Heckington Fen Solar Park

EN010123

Change Application Cover Letter

Change Application (our document reference – PreExA.CL.CA.v1)

APPENDIX 2 – ARBORICULTURAL IMPACT ASSESSMENT AND TREE PROTECTION PLAN

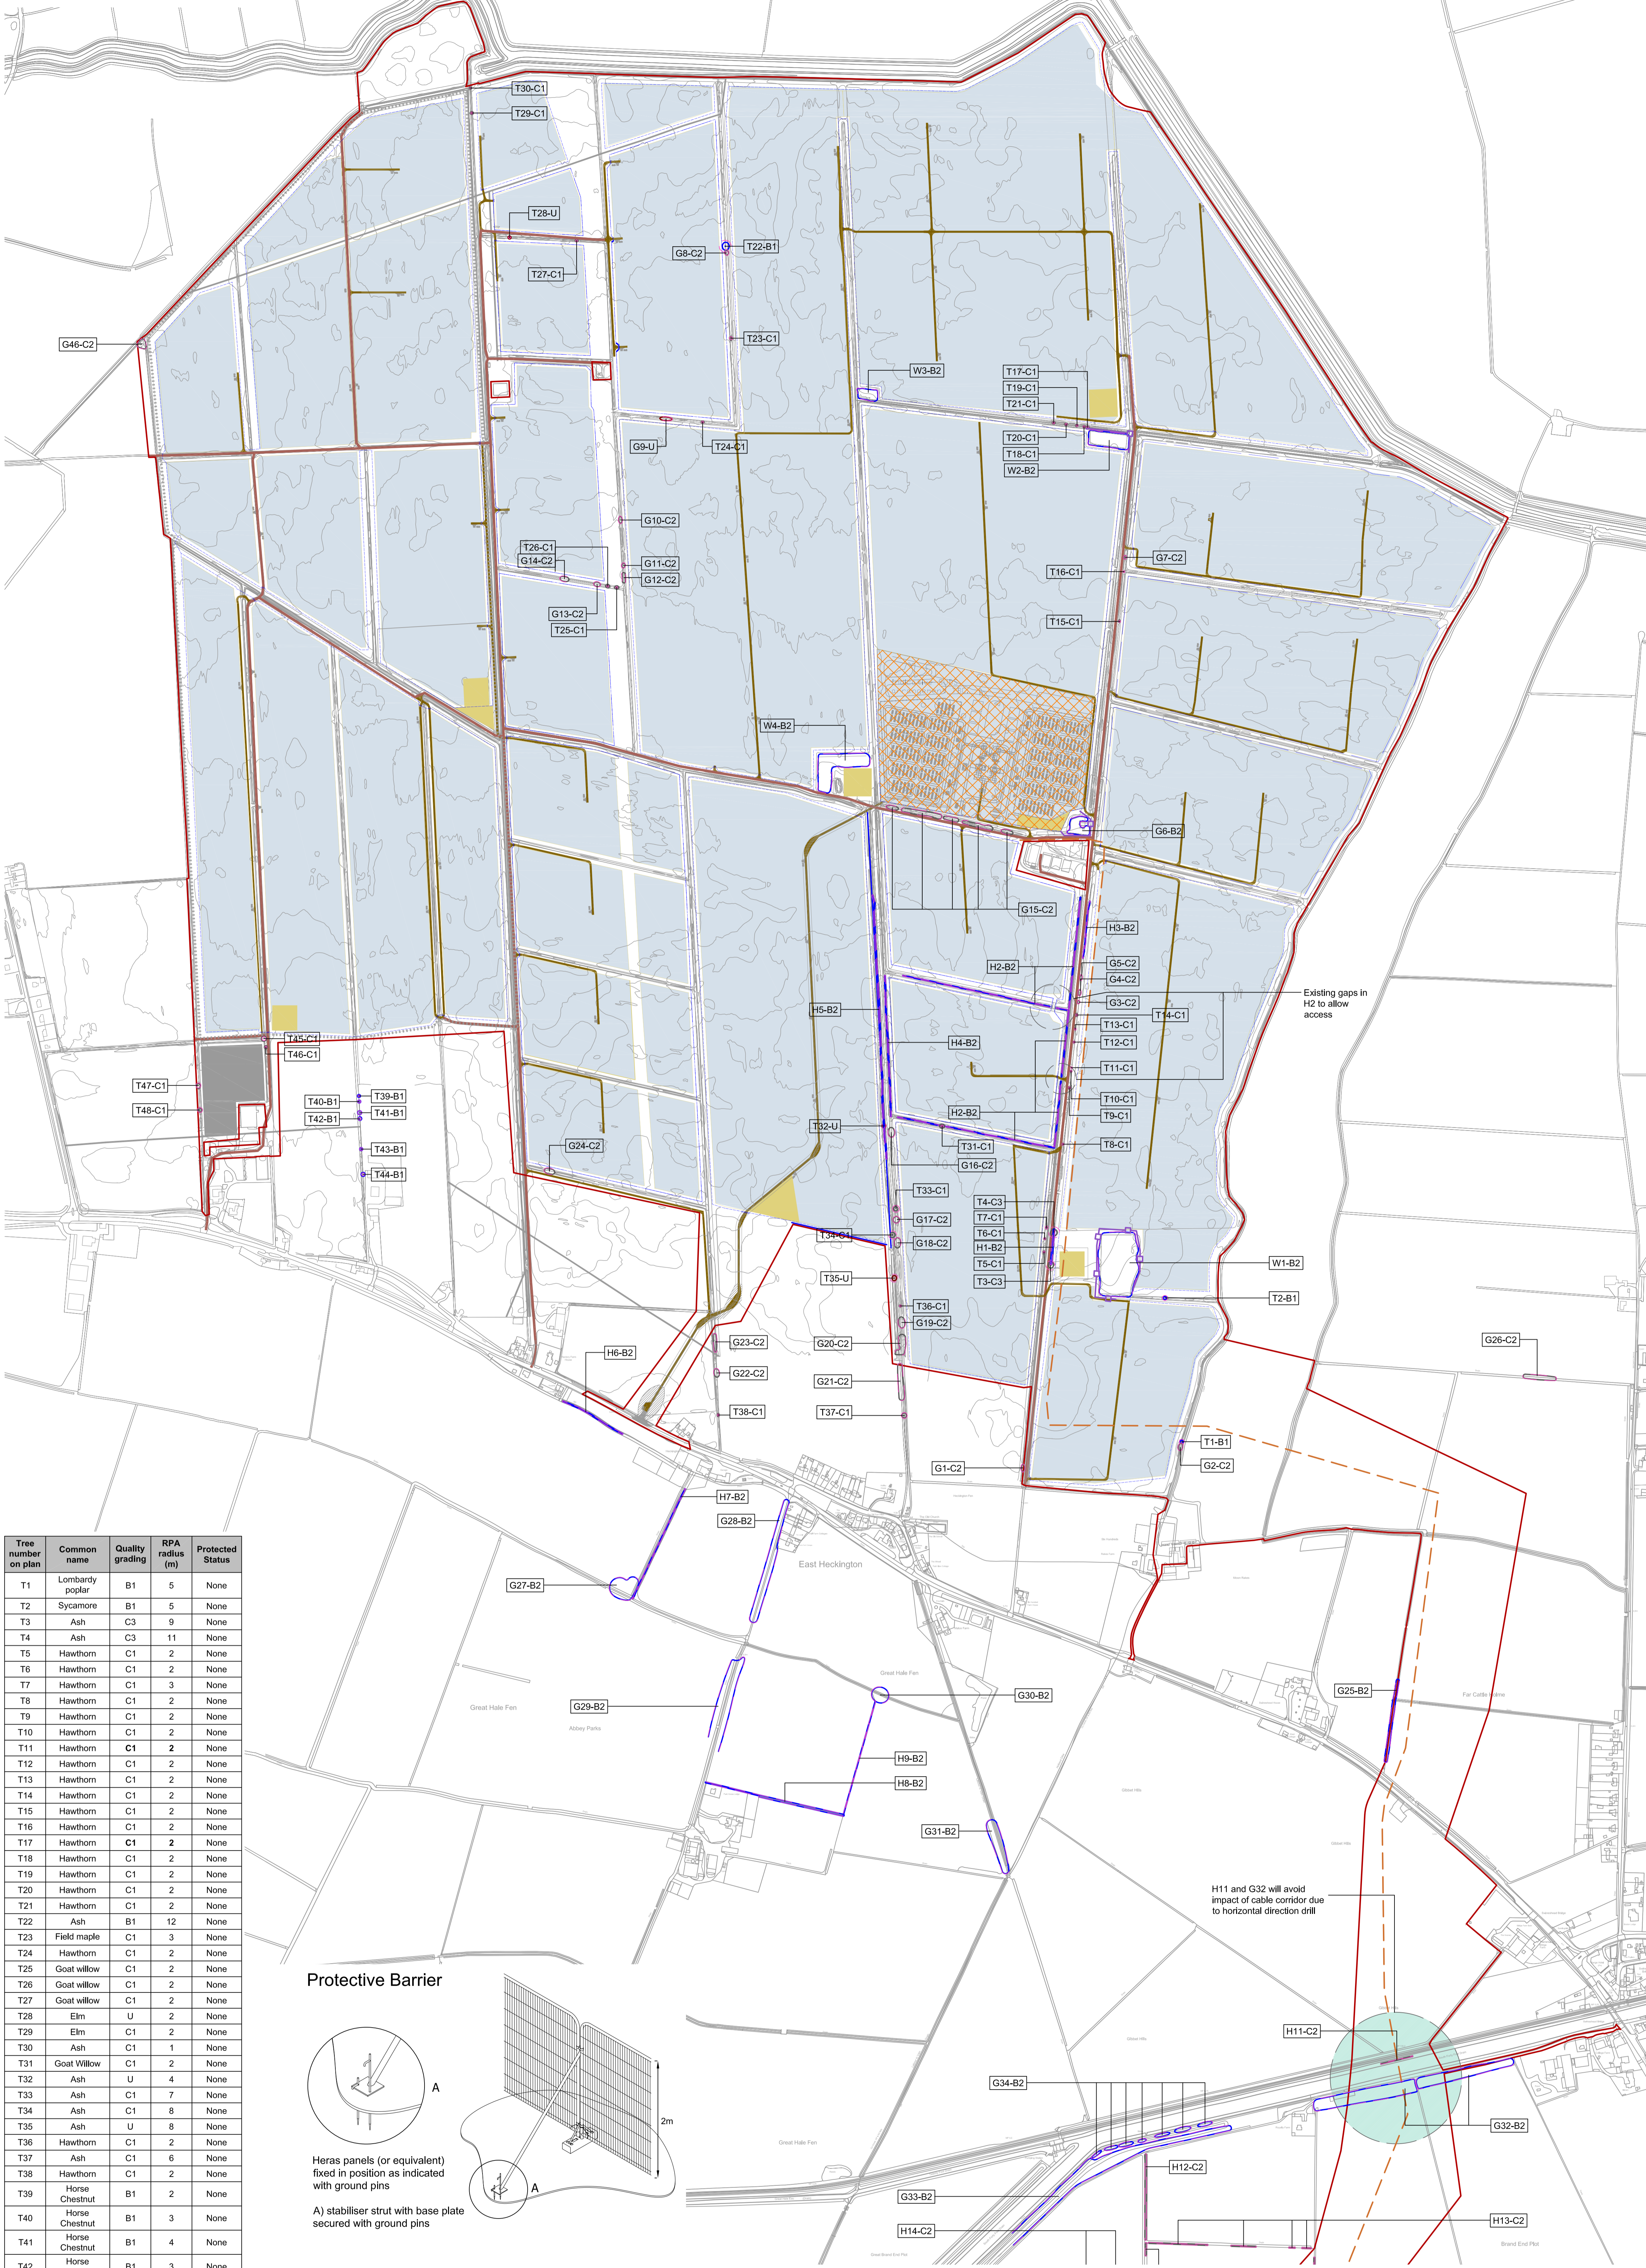
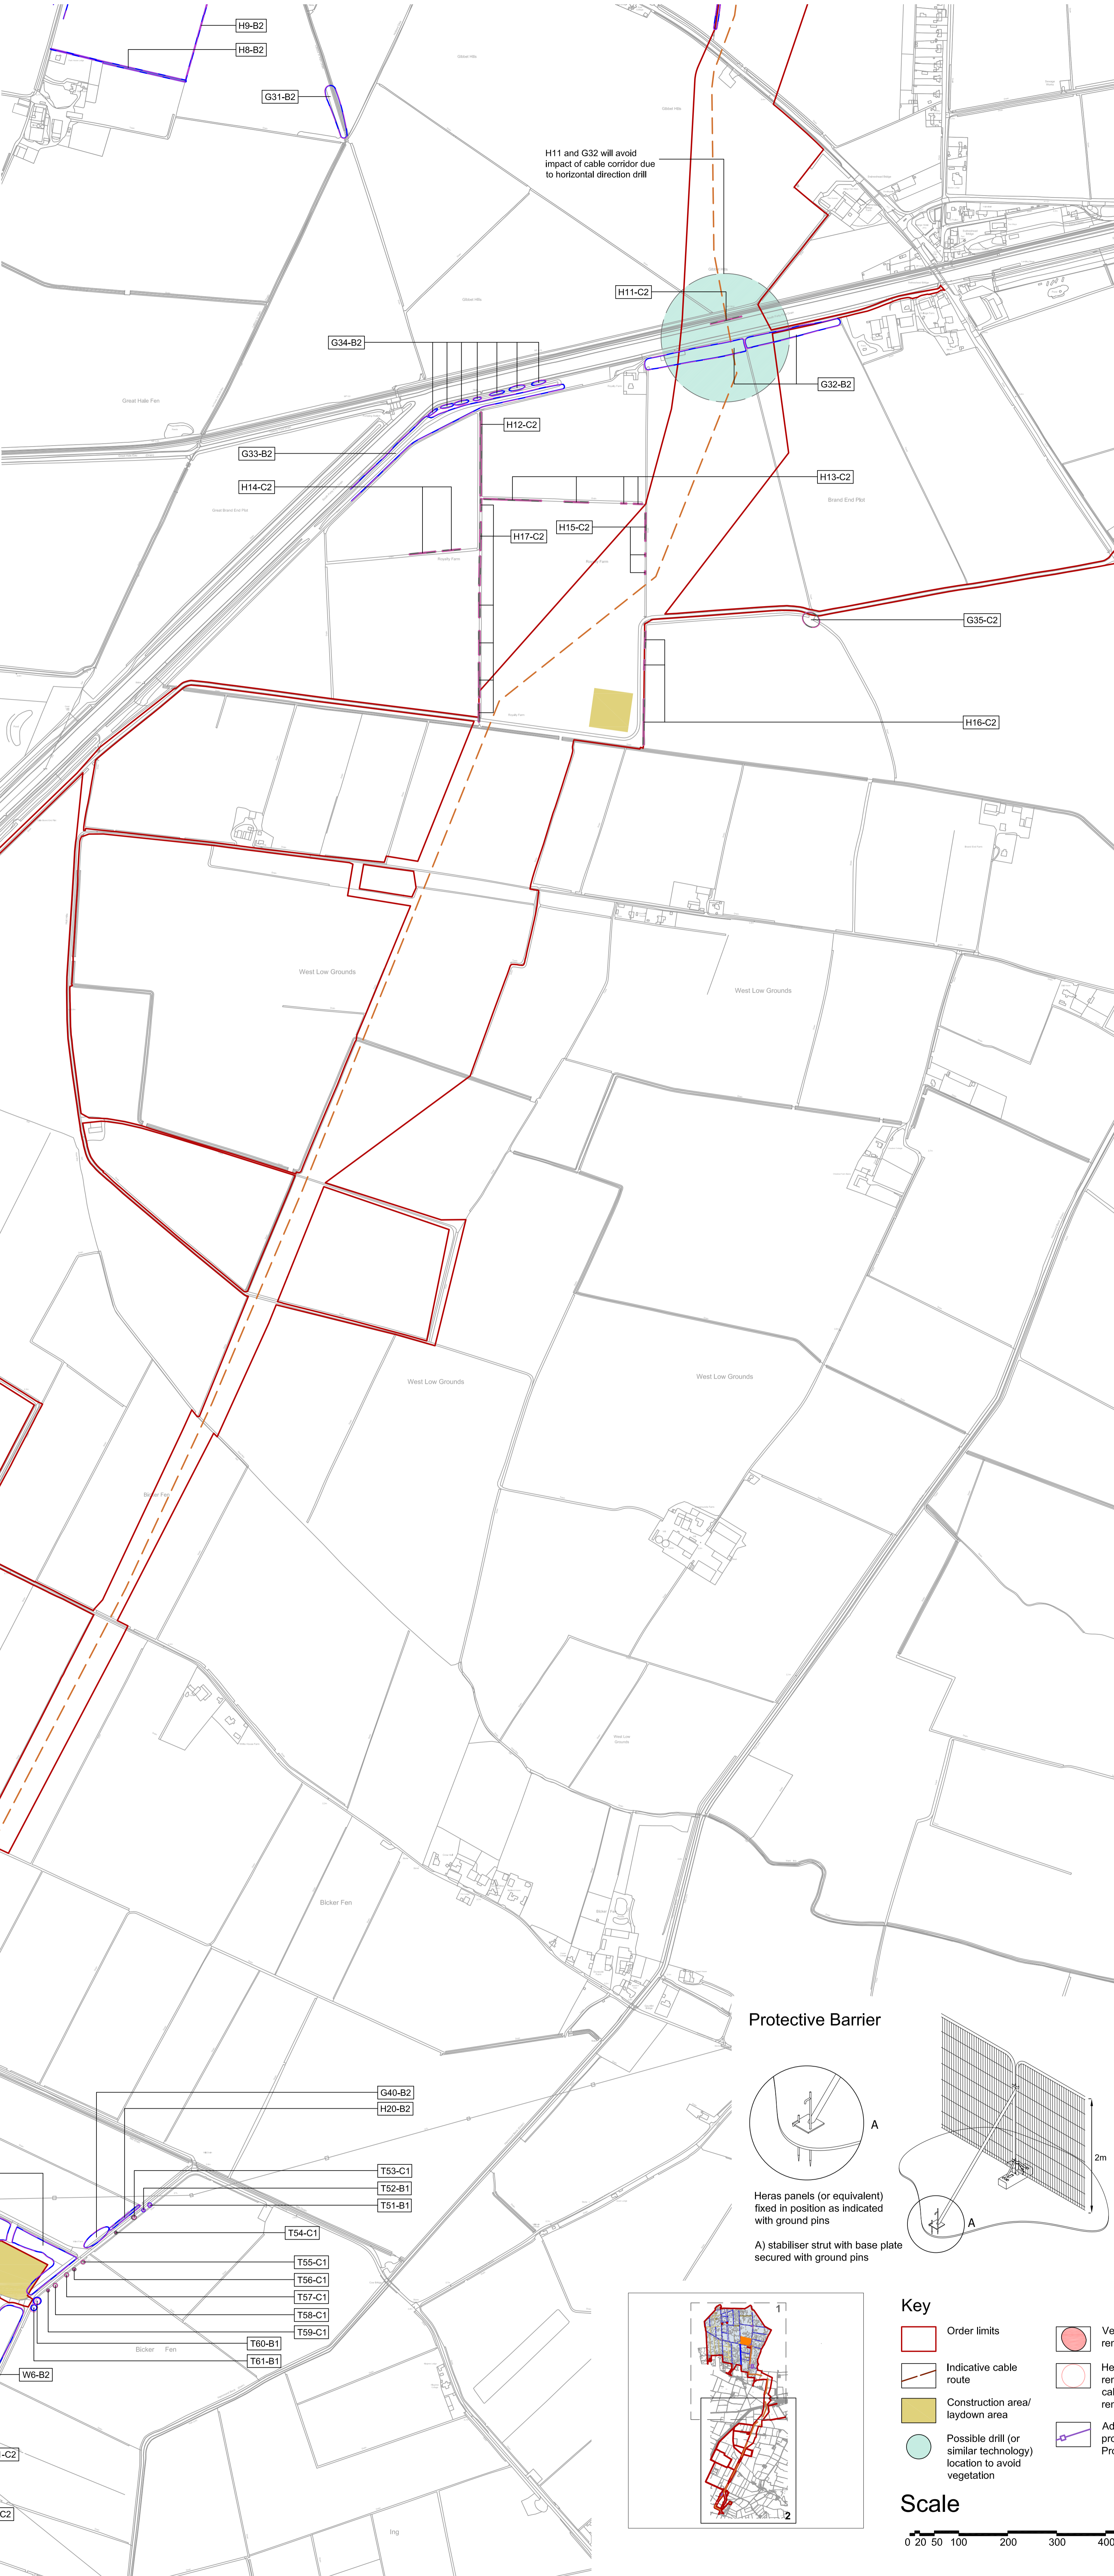
2. In the Arboricultural Report, at Appendix 6.3, which show an area of potential vegetation removal on the south west corner of Bicker Fen Substation (not associated with AW1) which we missed on the previous revision;

Drawing file: EN010123 / EN010123-000563-Pre-ExA.ChangeApp.ESFIG3.9.V1 - ES Figure 3.9 Change of Notification Areas at Bicker Fen National Grid Substation.pdf

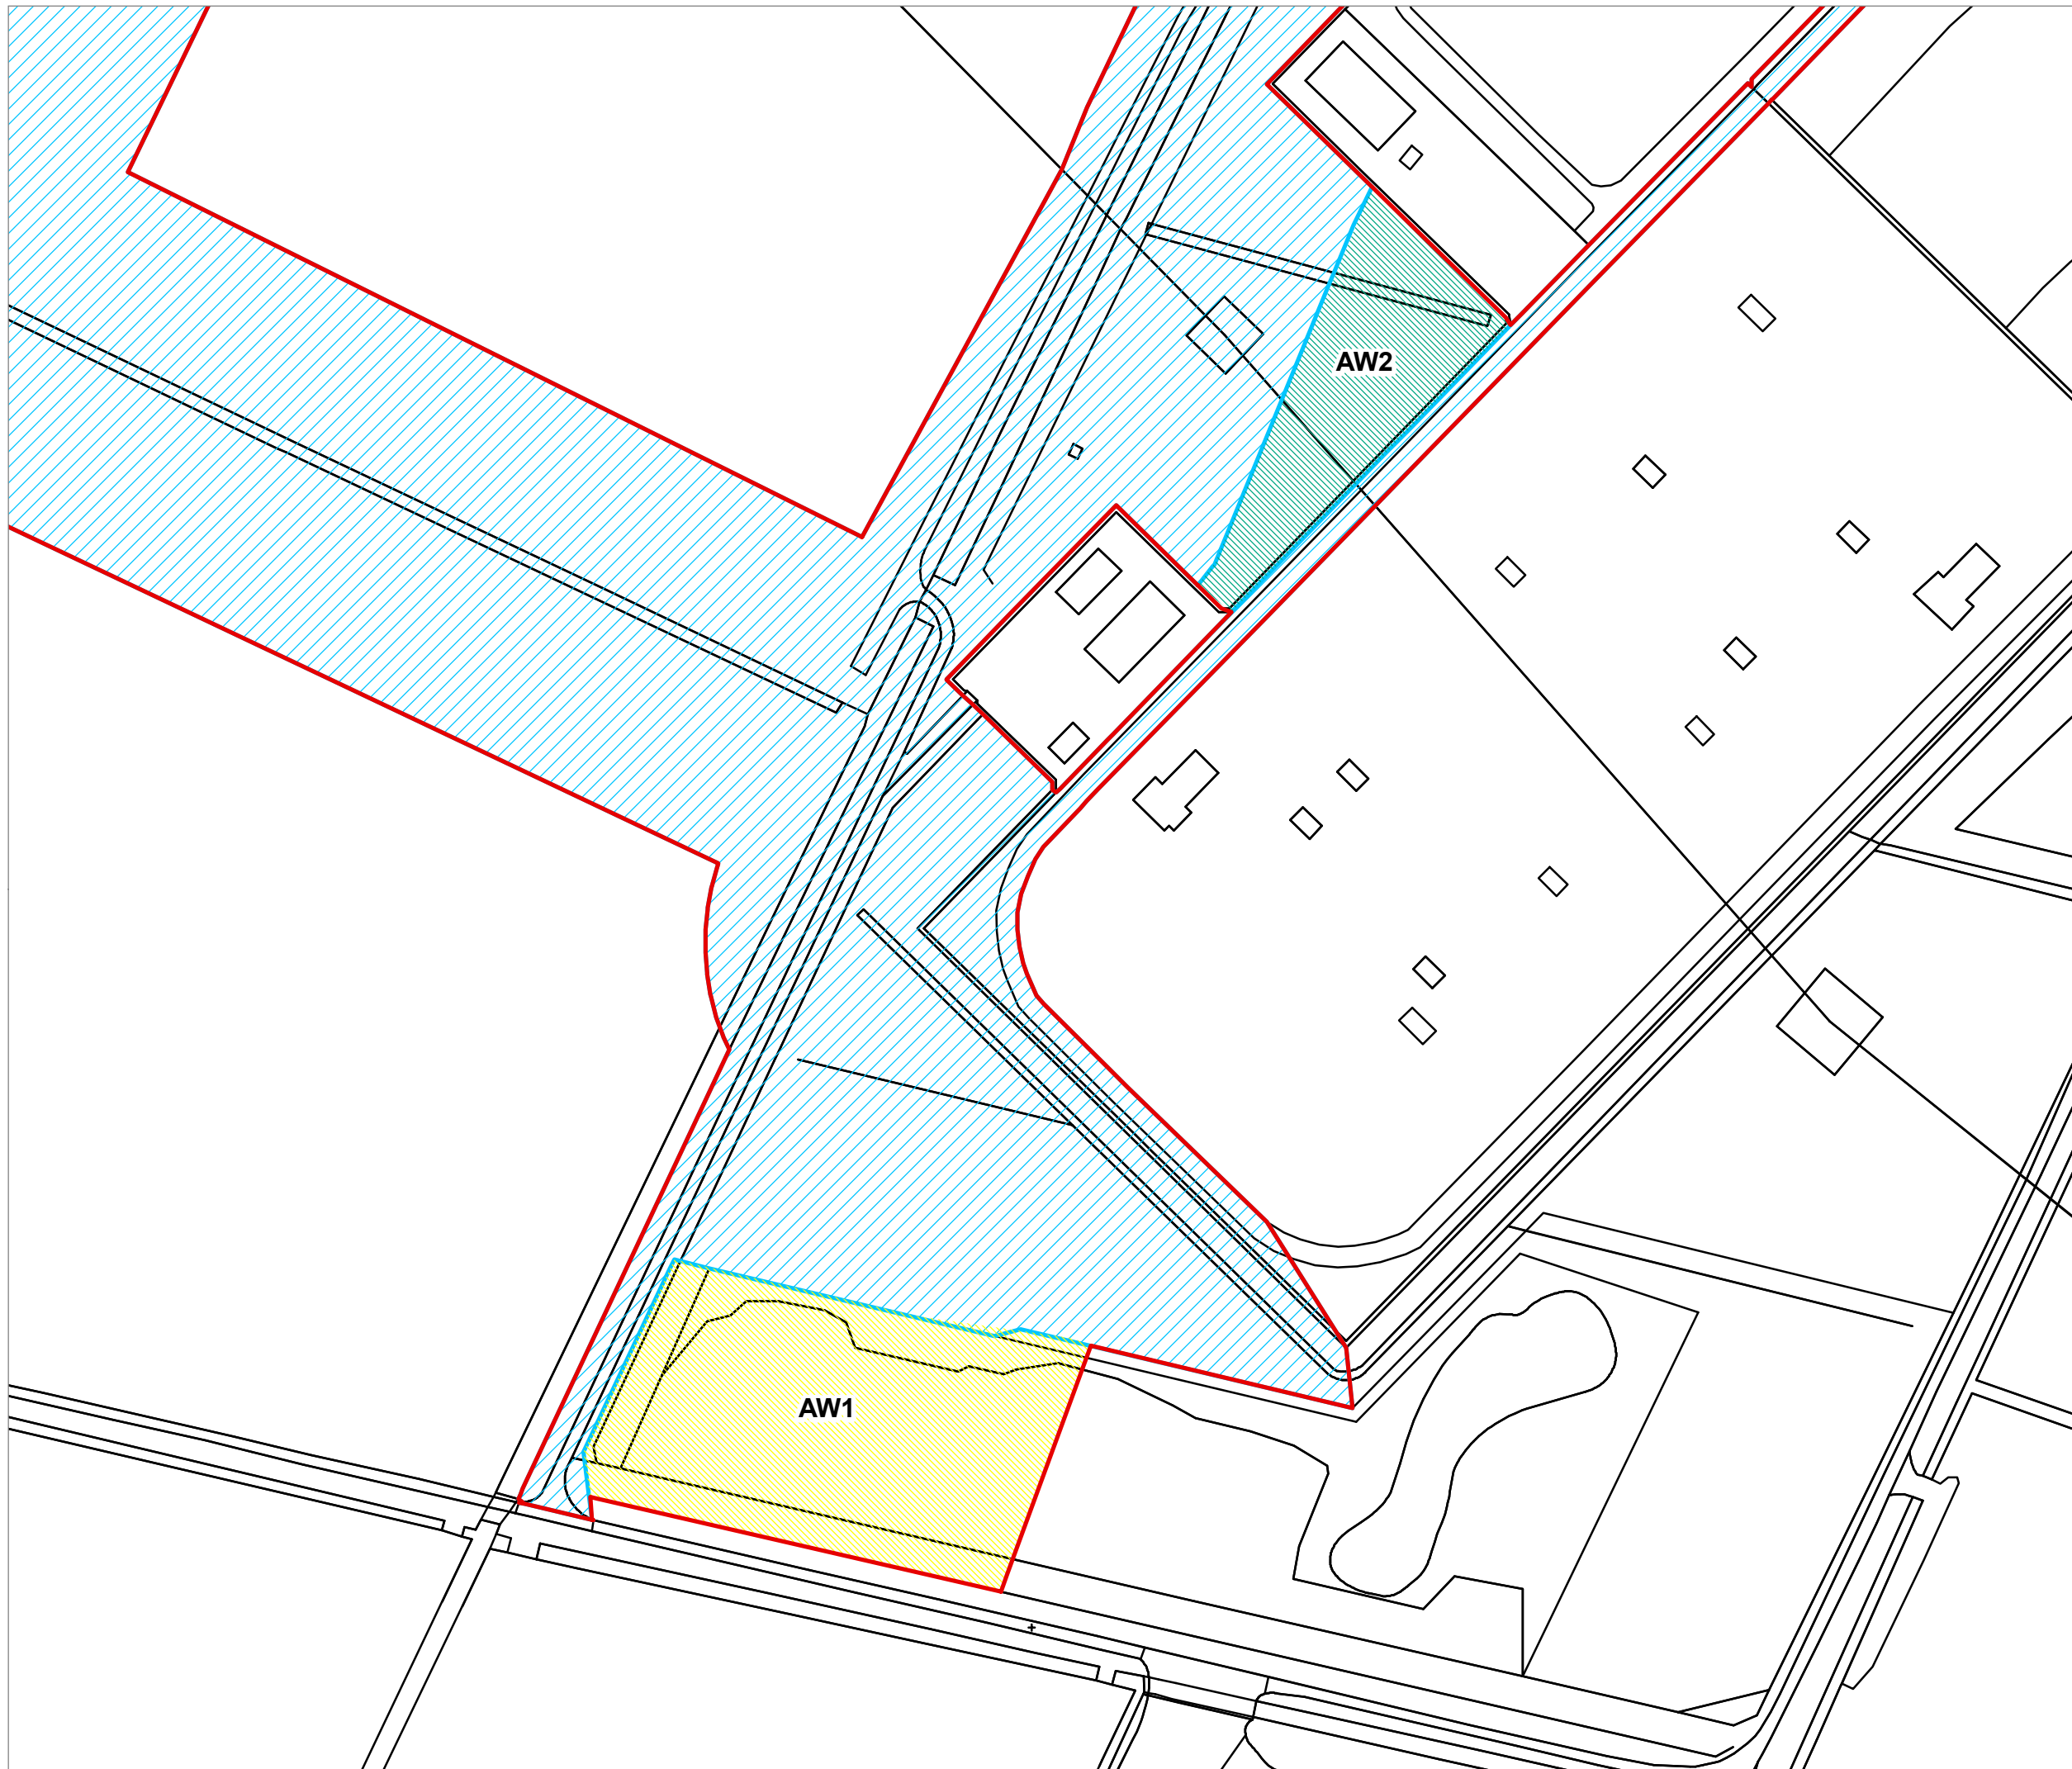
The proposed change relates to land at Bicker Fen Substation. Following submission of the Application, and as a result of ongoing discussions with National Grid Electricity Transmission (NGET), it has become clear that additional works at Bicker Fen Substation are required to enable the grid connection. These works lie outside of the current Order Limits at the Bicker Fen Substation. Accordingly, a larger area is needed at the Bicker Fen Substation to facilitate the Applicant's project, and this Change Application seeks to incorporate the additional land and works required.

1. a new section of NGET infrastructure at the Bicker Fen Substation comprising a busbar extension including a section breaker, a bus coupler and a feeder circuit on land to the south of Bicker Fen Substation, which is owned by NGET; and

2. a new cable sealing end ("CSE") compound on land to the west of Bicker Fen Substation which is owned by NGET.

As the ExA will see from the updated Land Plans (document reference 2.1, version 3) and the updated Book of Reference (document reference 4.3, version 3), two additional plots (plot 99H to the south, and plot 99I to the east) have been created for the additional land.
